2022 Financial Assurance Estimate Form (with pre-plat construction)

PROJECT INFORMATION		
The Cottages at Mesa Ridge	Date	4/1/2022
	PCD File No.

Financial Assurance Forms_v1 redline.pdf Markup Summary 5-12-2022

THE COTTAGES AT MESA RIDGE  
GOODWIN KNIGHT  
FOUNTAIN, COLORADO

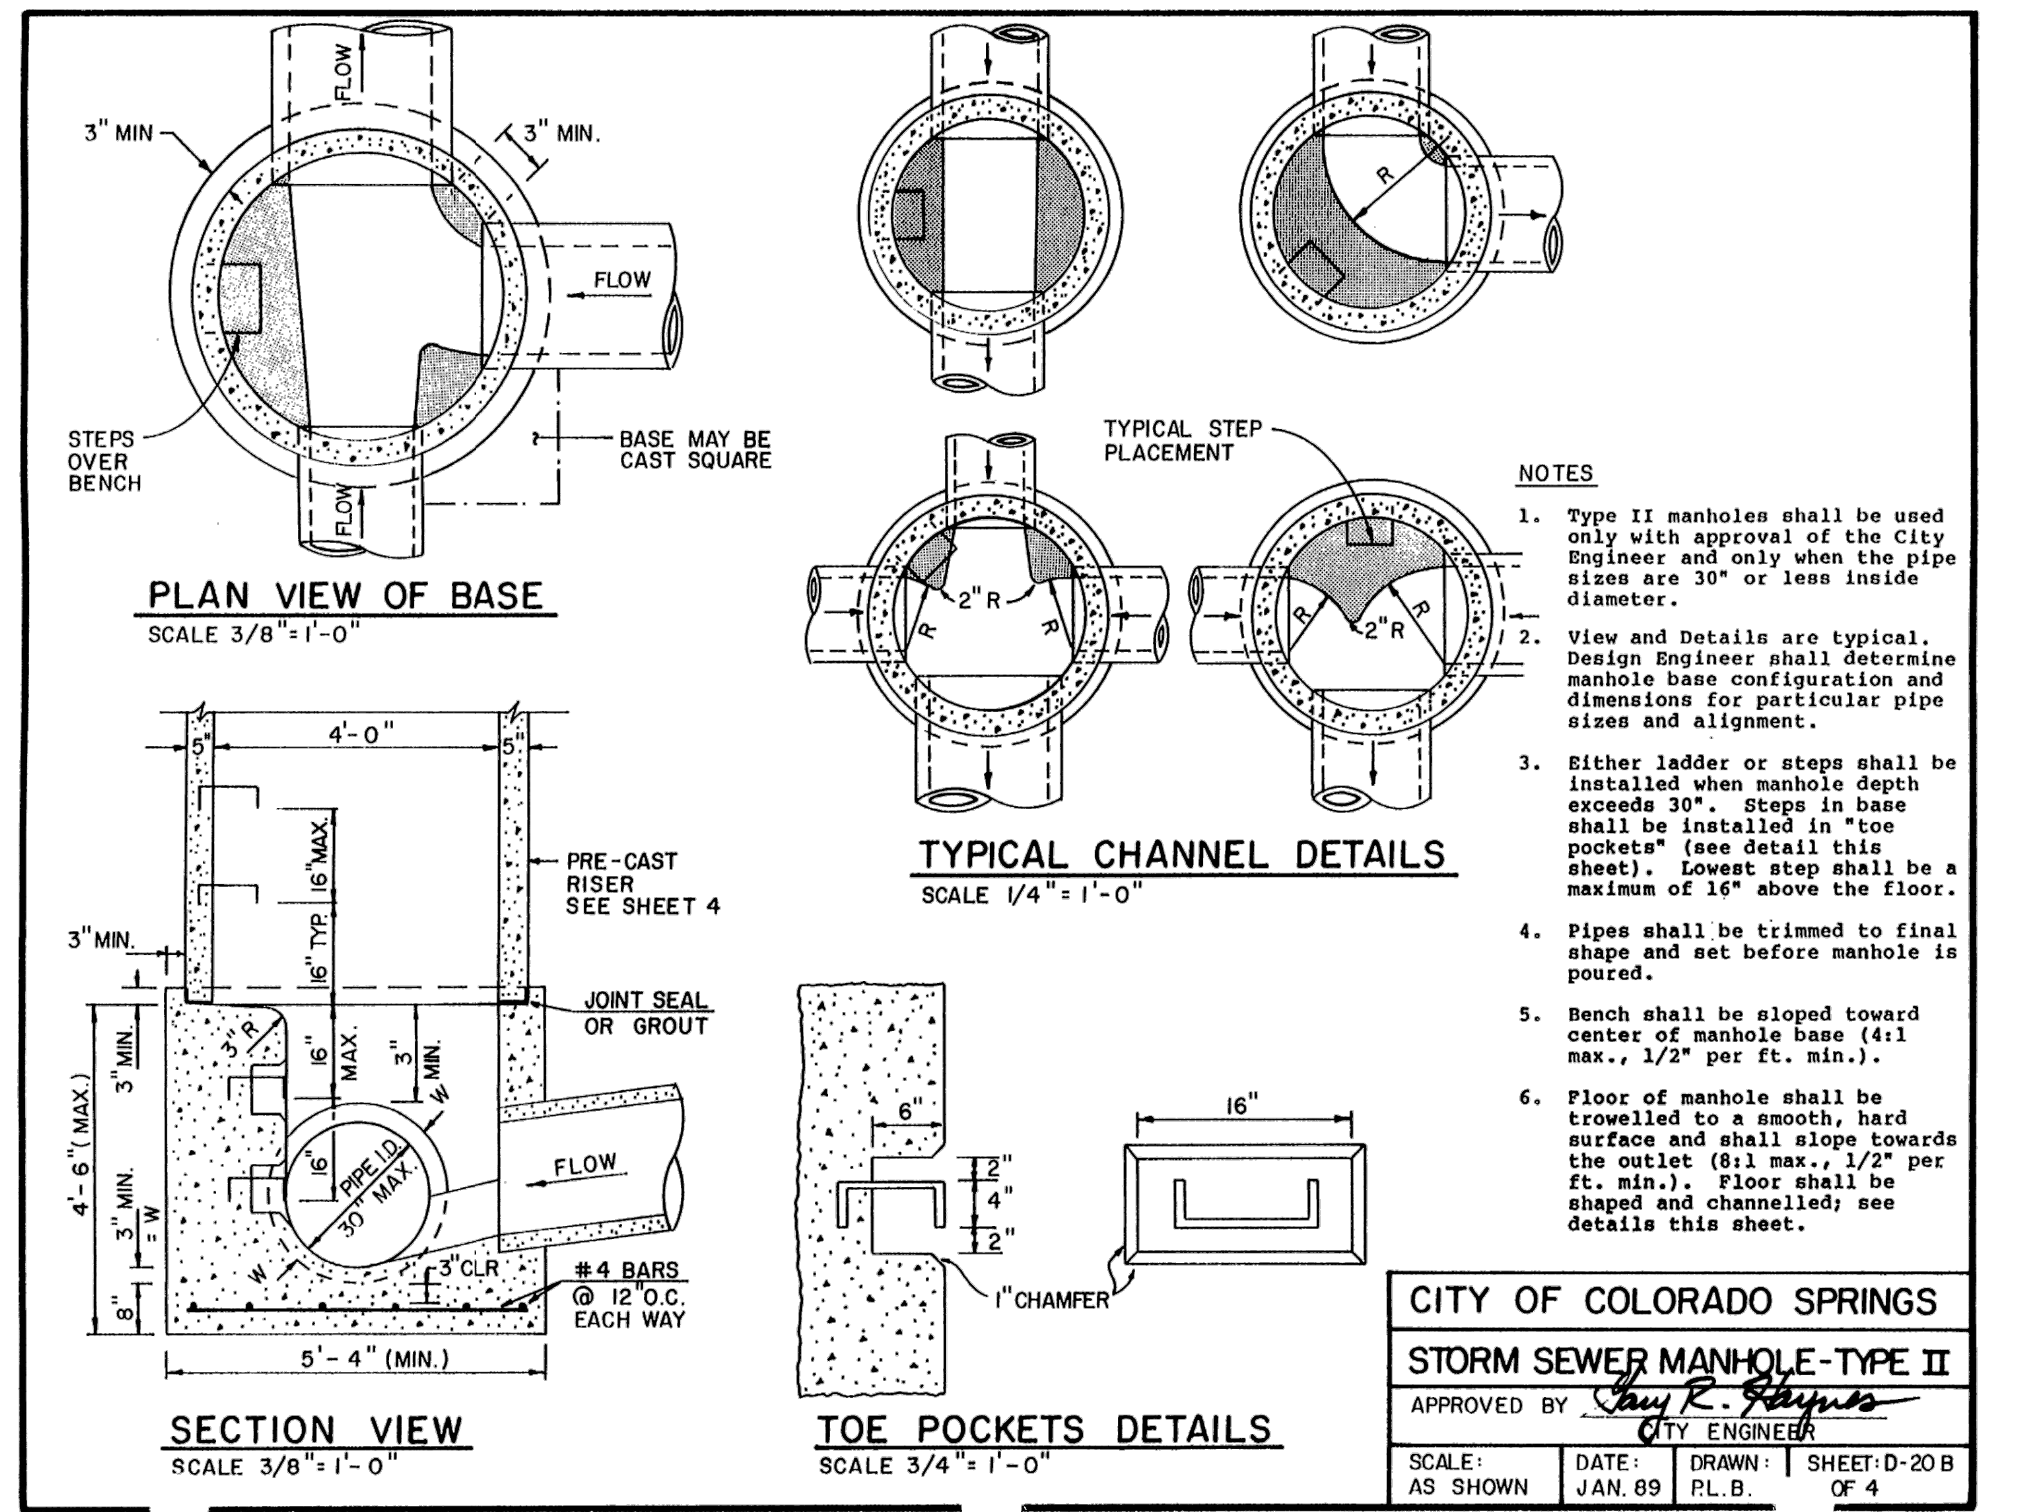
include outlet structure retrofit

HRG RESPONSE: ADDED TO SECTION 3
